2026-90232 – New Mills, Marsden - Off-site highway works drawings
Comments on Off-site Highway Works drawings by HDM (AD) on 16/09/2026

These comments are made following receipt of VIA drawings 23112-400 Rev F (Mill Road) and 23112-100 Rev E (Brougham Road).

SCALE: AS SHOWN @A3
 DATE: NOVEMBER 2025
 DRAWING NO: 23112-200
 STATUS: - REVISION: B

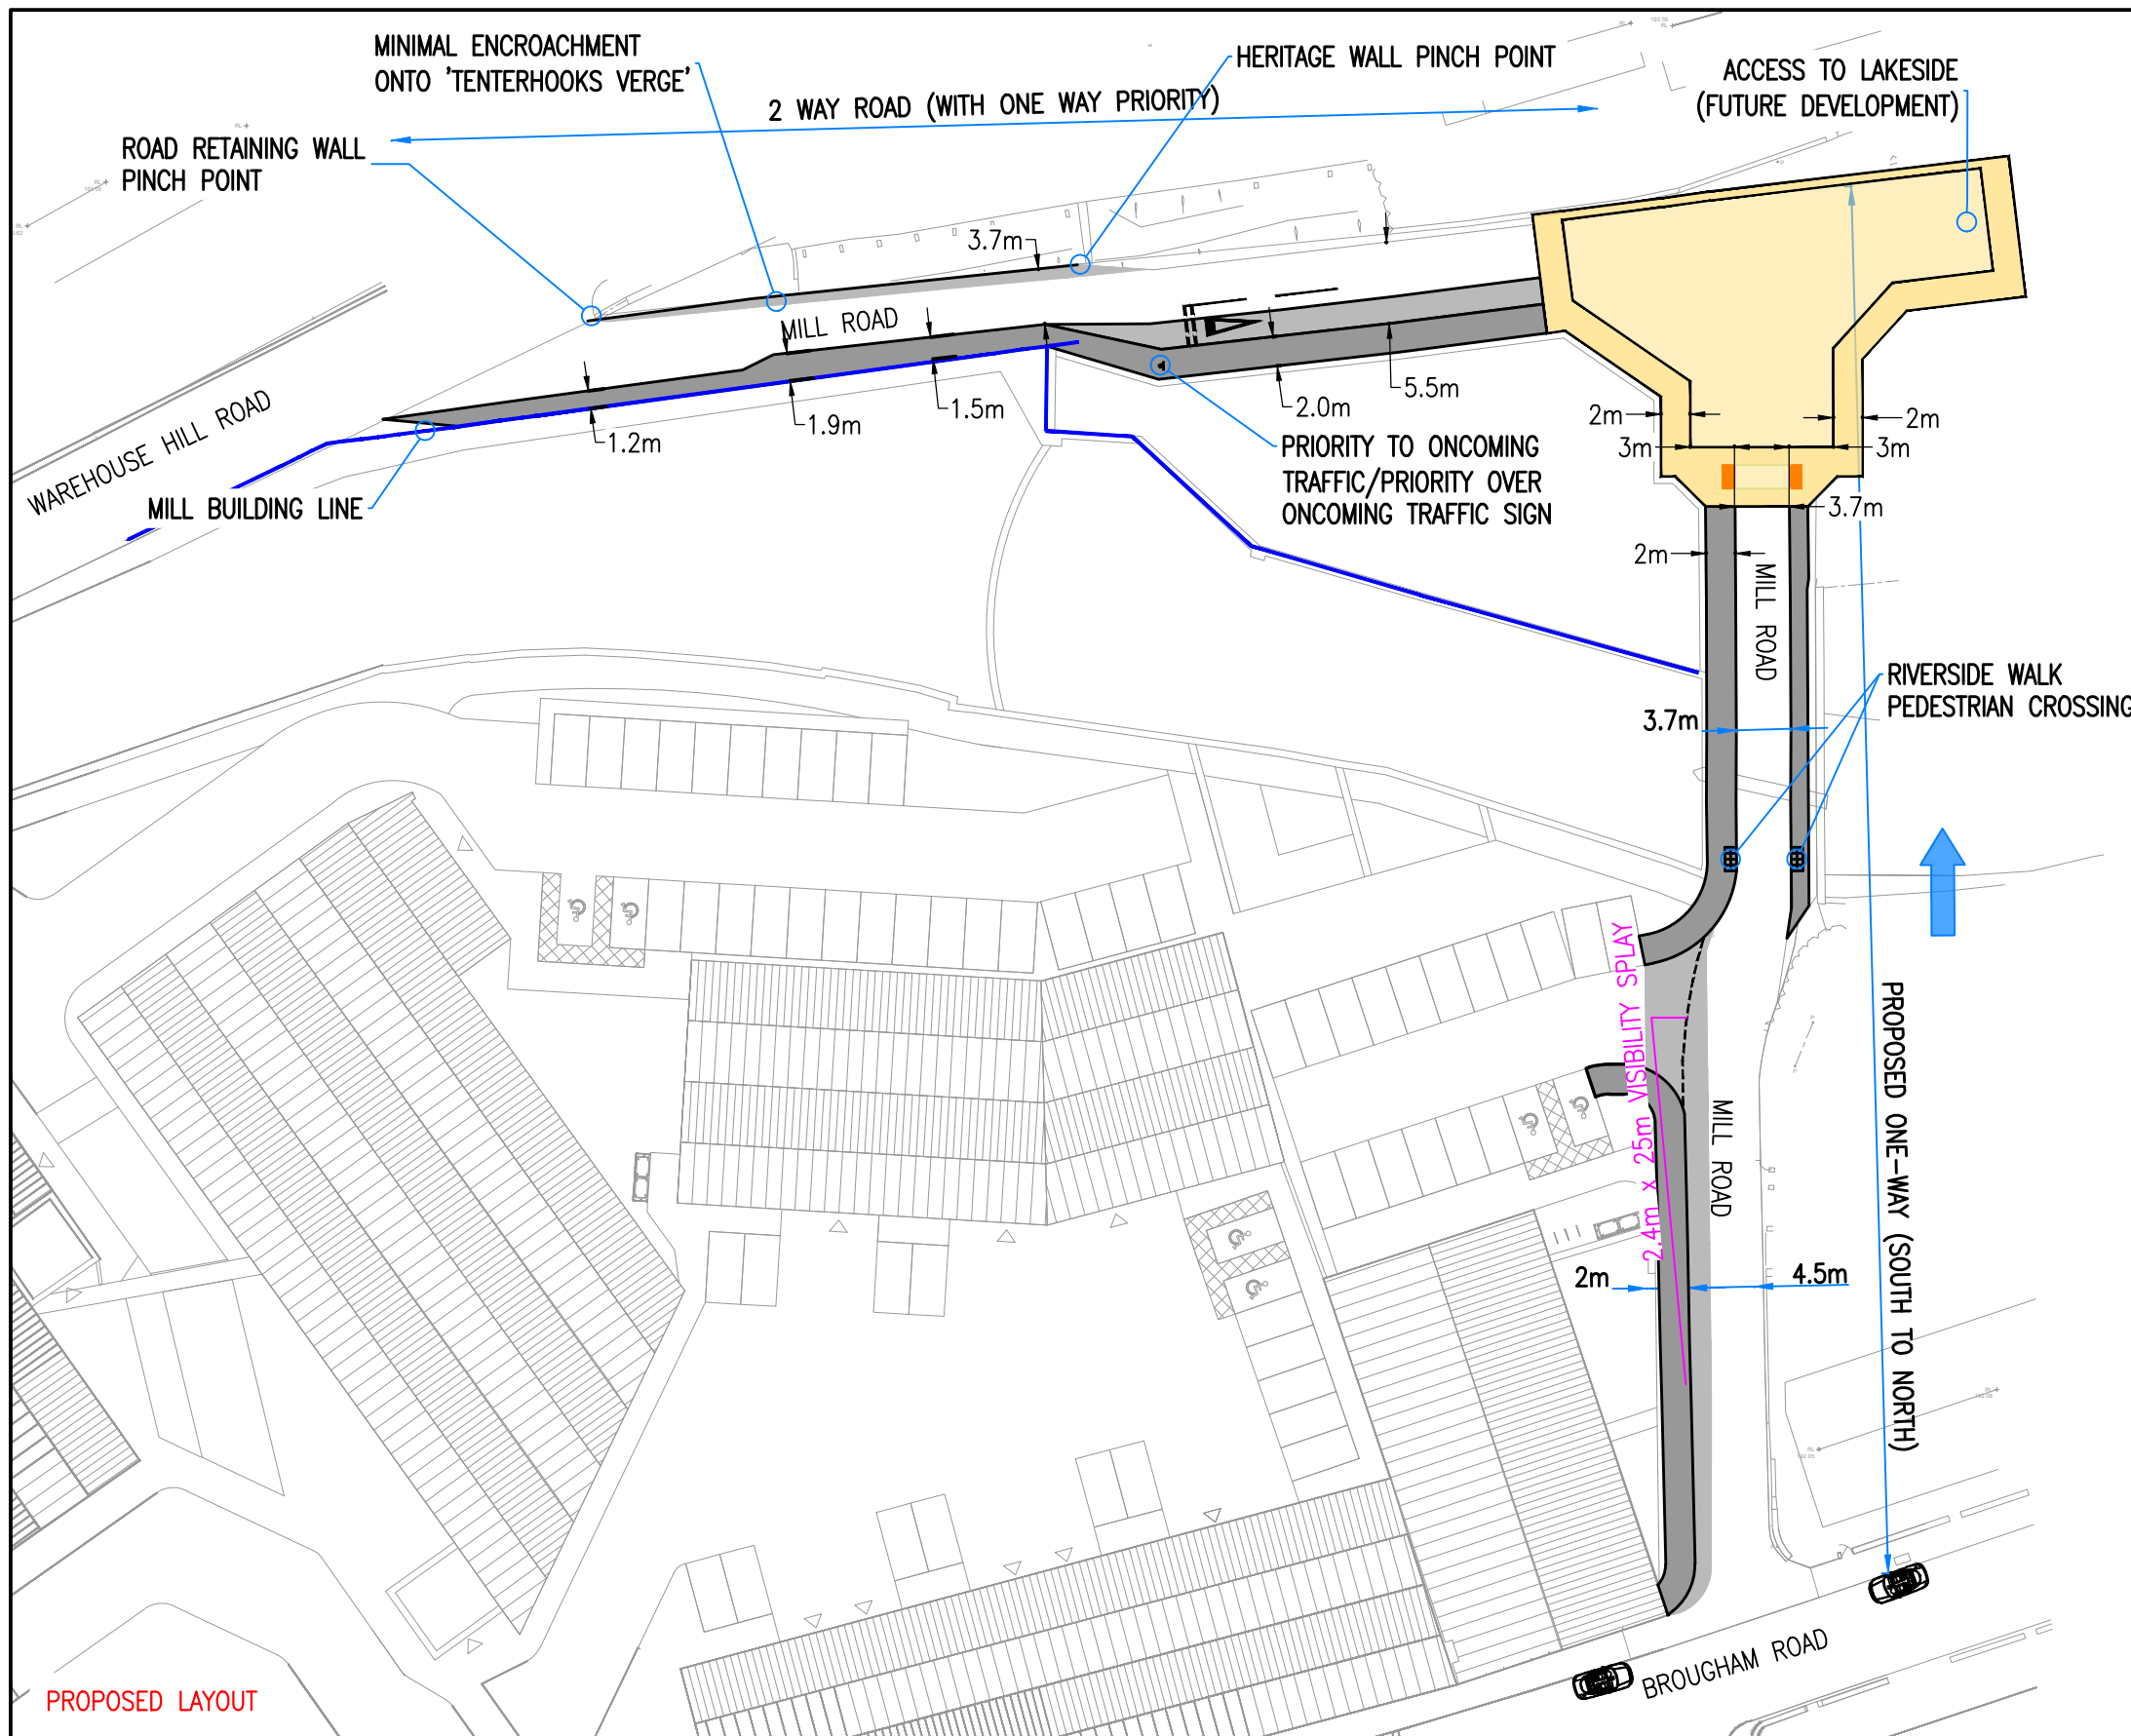
- DYL proposals to be added to composite plan showing all highway works, including the required lining at the Manchester Road junction.
- Swept path analysis required to confirm that the passing places that are being created by the DYL are effective. They will need to accommodate the Kirklees design refuse vehicle, although some footway overhang may be accepted (but to be avoided if possible, and to be reviewed by RSA1).
- Further comments on DYL proposal to be provided once further detail provided. However, the DYL should include the junction opposite Mill Road (also known as Mill Road, but understood to be unadopted).

DRAWING NO: 23112-400

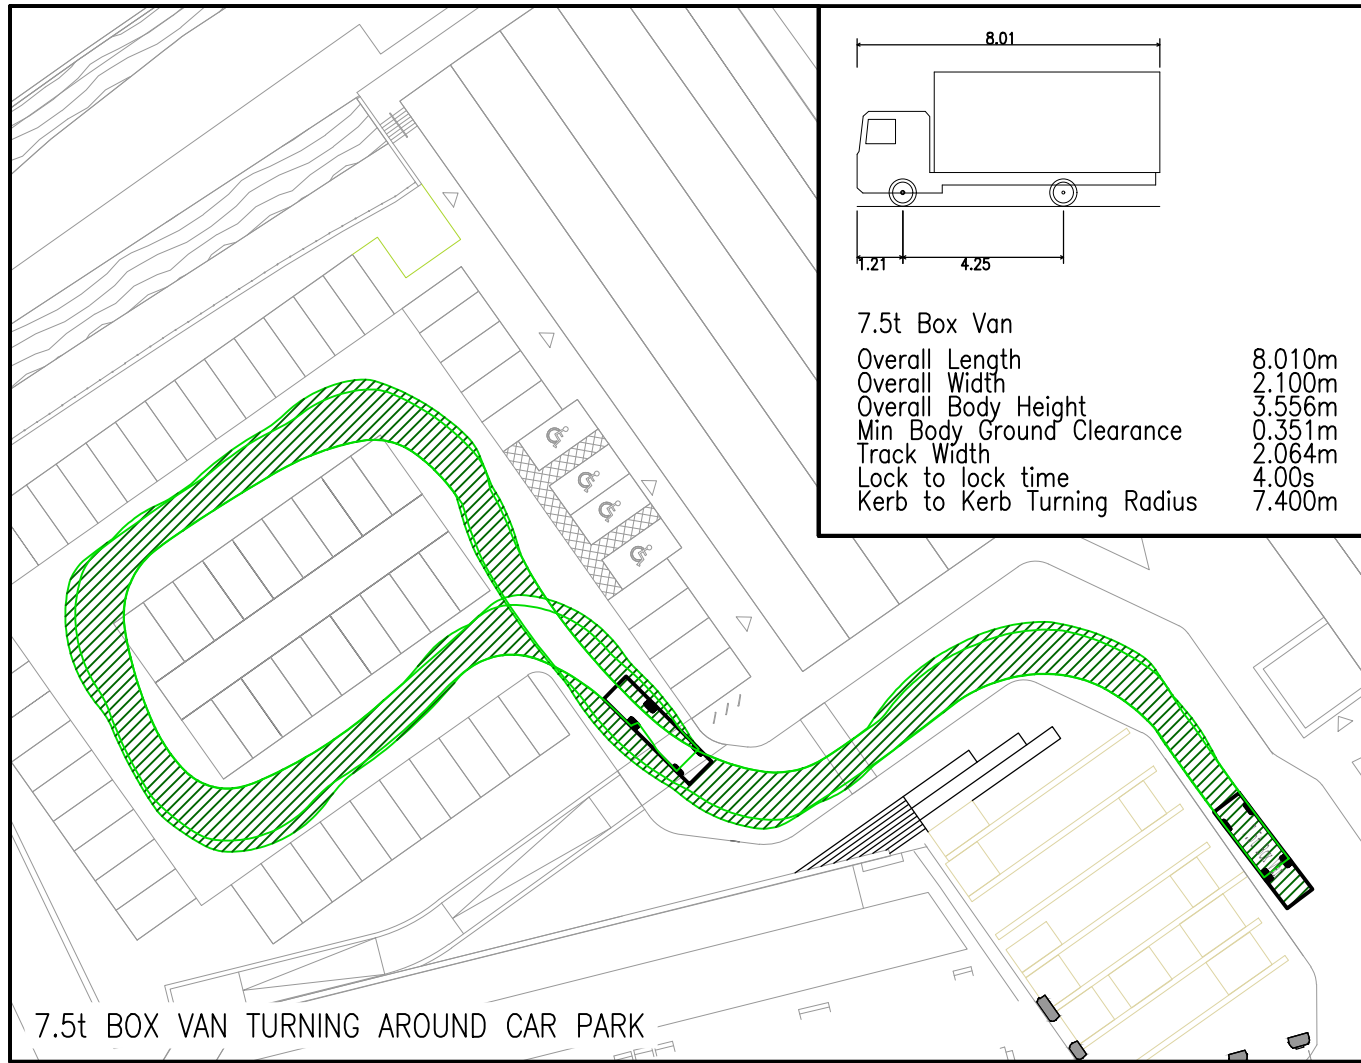
- Contra-flow cycle lane to be removed. This is due to safety concerns on southern section on approach to Brougham Road (steep uphill gradient and restricted visibility), and due to local concerns regarding pedestrian/cycle conflict on internal paths within the site. However, northern section of Mill Road (e.g. over the bridge) should include min. 4.1m carriageway width, which would enable a contra-flow cycle lane to be retro-fitted later, should this be desirable in future (e.g. as part of the wider Blueprint access Strategy), or to allow a car to pass a waiting car (or to pass an oncoming cyclist that may choose to contravene the one-way restriction).

- Existing footway on east side of Mill Road (e.g. over the bridge) should not be reduced in width. This appears achievable, whilst still providing min. 4.1m wide carriageway and 2m wide (or just under) footway on the west side.

- Riverside path route to still be provided at 3m wide. This will enable cyclists to dismount and use this route to access the wider scheme (and/or enable future upgrade to shared use), and to provide seating and other street furniture along the route. Cycle route warning paving to be removed. Cyclists dismount sign to be provided as the route starts at Mill Road.

- 1x25m pedestrian visibility splays to be shown at dropped crossing on Mill Road at riverside path access.
- 2 no. one-way signs to be provided on entry to Mill Road from Brougham Road. Additional 'Ahead Only' text and arrow marking to be provided in vicinity of office access to re-enforce one-way (additional signage may also be required – see TSRGD and TSM).

- 2 no. No Entry signs to be provided at north end of one-way section, with no entry text. Give-way markings and signage provided on entry to turning head.

- Swept path analysis to be provided to demonstrate 7.5T van reversing into office access for servicing. If waste collection access proposed for office from Mill Road, it

needs to be demonstrated that level gradients available to/from rear of refuse vehicle, and that cars can pass stationary refuse vehicle.

- Swept path analysis to confirm what size vehicles can turn left/right into Mill Road from Brougham Road. TRO may be needed to prevent large vehicle accessing Mill Road once maximum vehicle size is determined.

- Swept path analysis is required to confirm that turning head at Lakeside area can accommodate the Kirklees Design Refuse vehicle. This turning head should also not be raised, as this is unlikely to be permitted in such close proximity to the bridge (See road hump regulations).

- It is recommended that redline is extended well beyond the turning head (and covering all the highway works to Mill Road), as additional accommodation works are likely to be required to ensure suitable tie-in arrangements.

- DYL reference to be added to drawing key.
- The 'minimal' encroachment to the 'Tenterhooks verge' needs to be avoided, with the 3.2m wide carriageway achieved without impacting the existing kerblines. This may require the adjacent footway to be reduced slightly below 1.5m, but this can be accepted by DfT document 'Inclusive Mobility' if the pinch point is a minimum of 1m for no more than 6m. However, it appears feasible to widen the footway in this location in any case, due to the location of the river walls being offset at this point.

- Swept path analysis is required to demonstrate the priority working arrangements are workable.
- The priority working signage locations need to be reviewed (e.g. sign locations need to be identified for both approaches, and located so as not to create unacceptable pinch-points).

- No through road signs are required at Mill Road / Warehouse Hill Road junction.
